29 August 2019
Ref No: 2682-1190

**Modification to Development Consent SSD 9575 – Tweed Valley Hospital
Stage 1 Early and Enabling Works**

The Section 4.55(1A) modification application seeks to modify Development Consent SSD 9575 by way of amending the approval applicable to the Stage 1 Works and associated vegetation clearing. An inconsistency has been noted in the proposed vegetation clearing areas to be undertaken as part of the Stage 1 Works (SSD 9575). The inconsistency is in the areas presented in the Stage 1 Biodiversity Development Assessment Report (Stage 1 BDAR), the SSD 9575 Conditions Schedule 3 B33(c), and the latest detailed design information prepared by Robert Bird Group (Project Civil Engineers). To clarify this inconsistency, we have included the most recent (Stage 2) BDAR for the project.

## TREE REMOVAL AND PRESERVATION PLAN

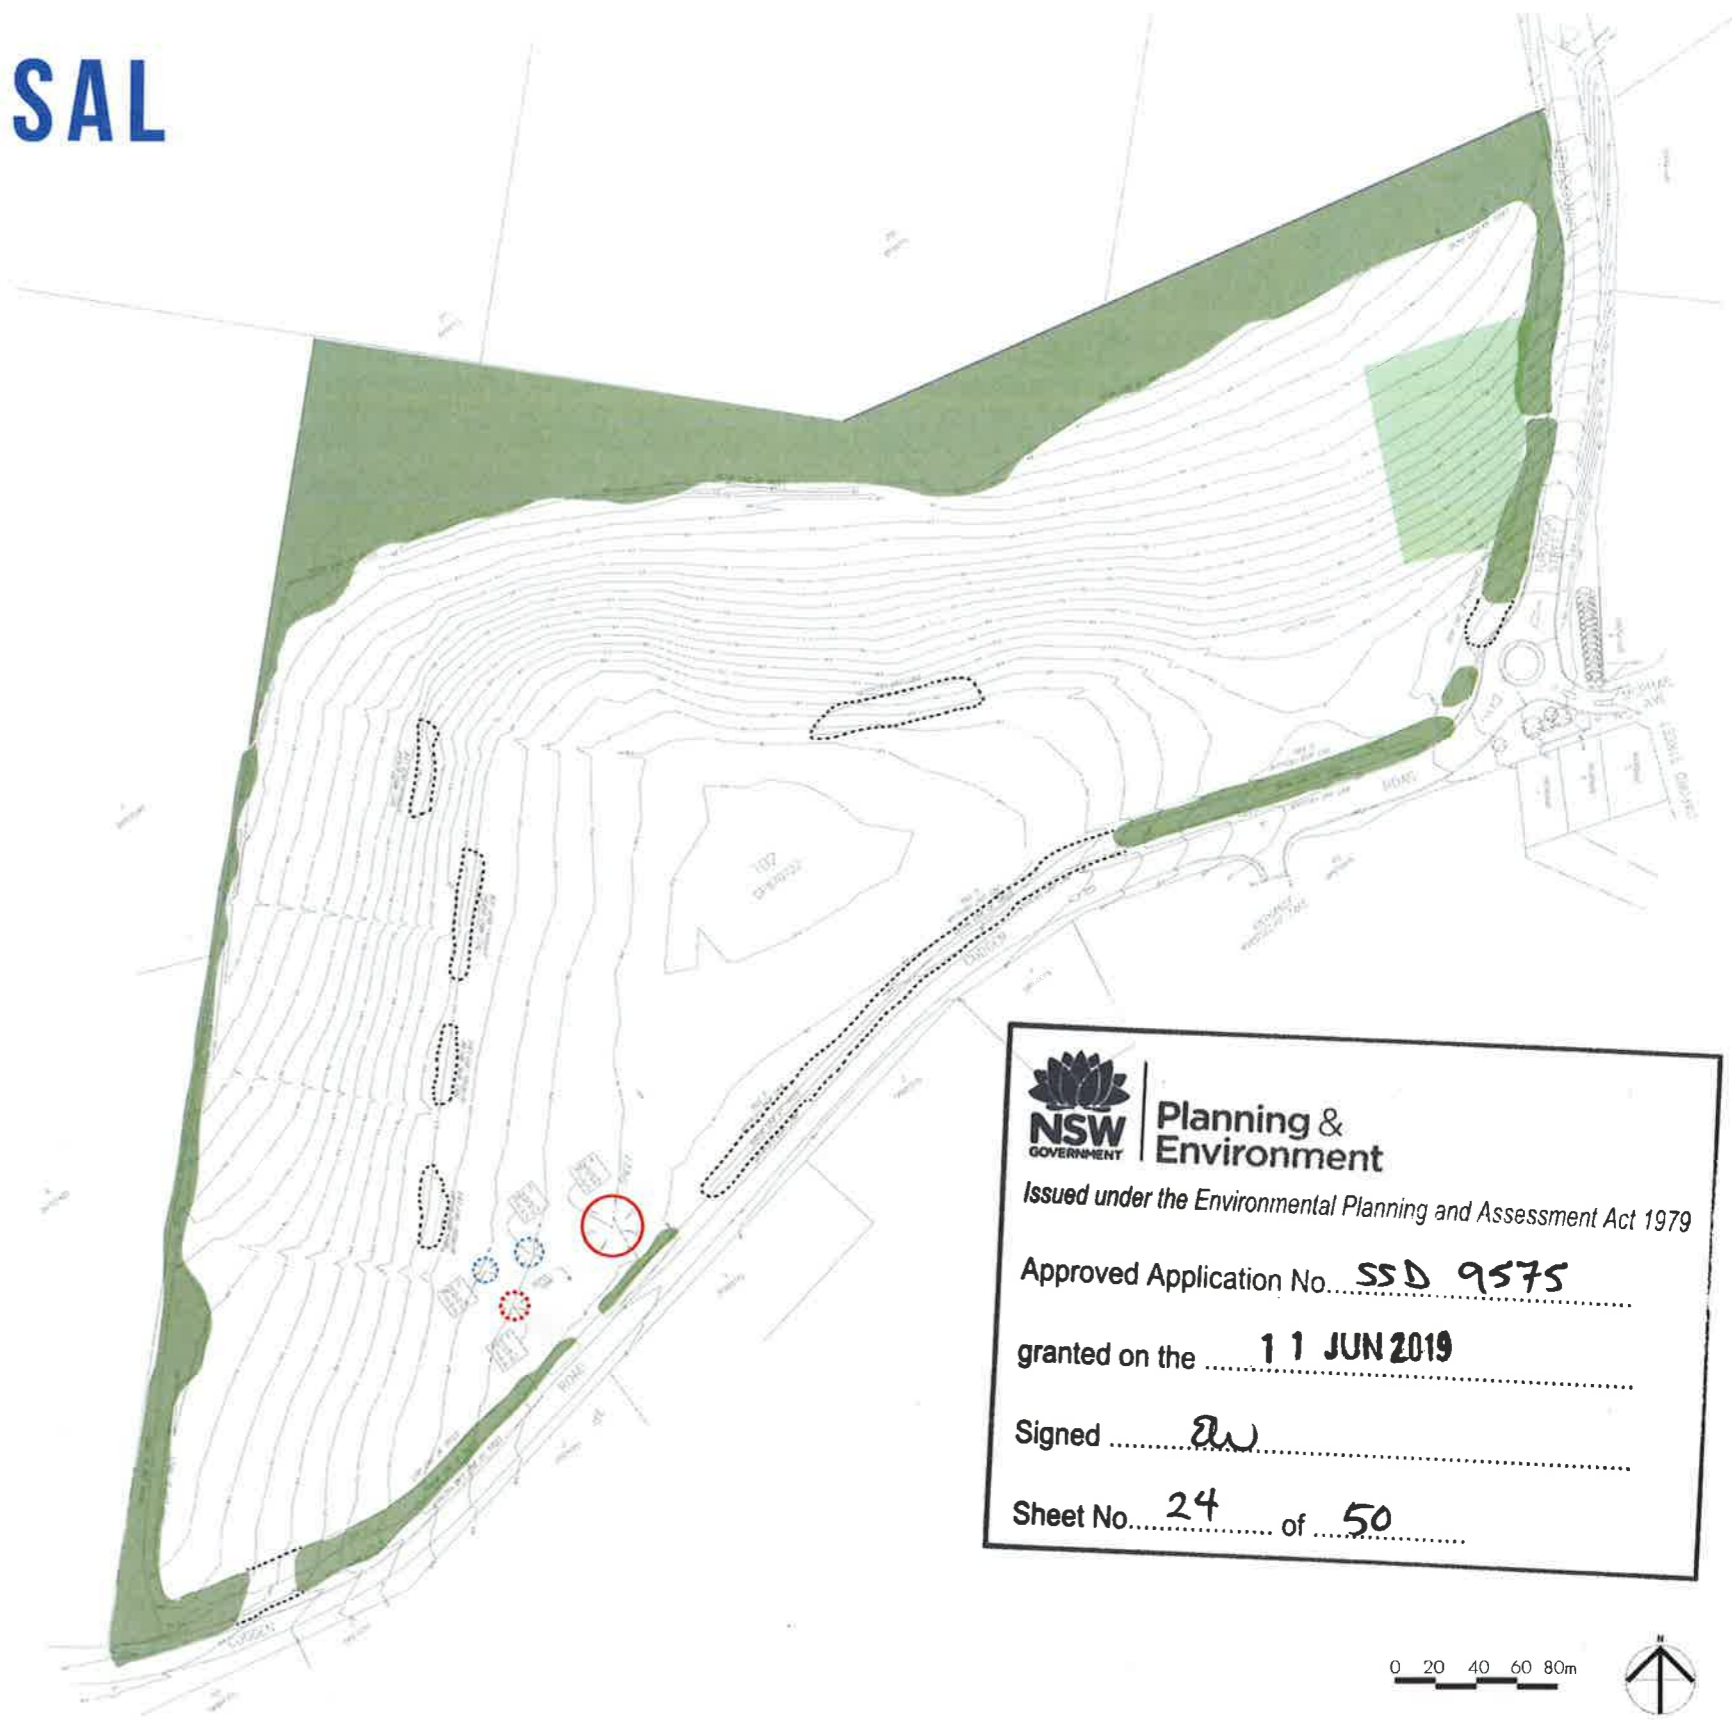
Prior to submission of the Stage 1 EIS, the vegetation clearing plans were updated but not reflected in the previously completed Stage 1 BDAR assessment. The relevant plans, as approved in SSD 18_9575, are:

- *Drawing No L-EIS-1 Rev F Tree Removal and Preservation Plan* (3rd May 2019, Turf Design Studio).
- *Preliminary Arboricultural Report* (17th October 2018, ArborSafe).

Georeferencing of these plans by Greencap and application to vegetation mapping from the BDAR indicate that a total of **0.84 ha** of native vegetation was to be cleared (**Table 1**).

As a consequence of the modification, SSD 9575 Condition Schedule 3 B33(c) also requires amendment to reference the revised Tree Removal and Preservation Plan submitted with this application.

The updated Turf Design Studio *Drawing No LS-DWG-02-001 Tree Removal and Preservation Plan* dated 27th of August 2019 incorporates the recent detailed designs by Robert Bird Group for the roundabout and auxiliary lane dated the 26th of August 2019 and the main entrance dated the 16th of August 2019.

The Turf Design Studio *Drawing No LS-DWG-02-001 Tree Removal and Preservation Plan* dated 27th of August 2019, georeferenced by Greencap and applied to the vegetation mapping from the BDAR, indicates that a total of **0.93 ha** of native vegetation is to be cleared (**Table 1**). A visual representation of the differences in indicative clearing areas based on the best available information provided to Greencap is shown in **Figure 1**.
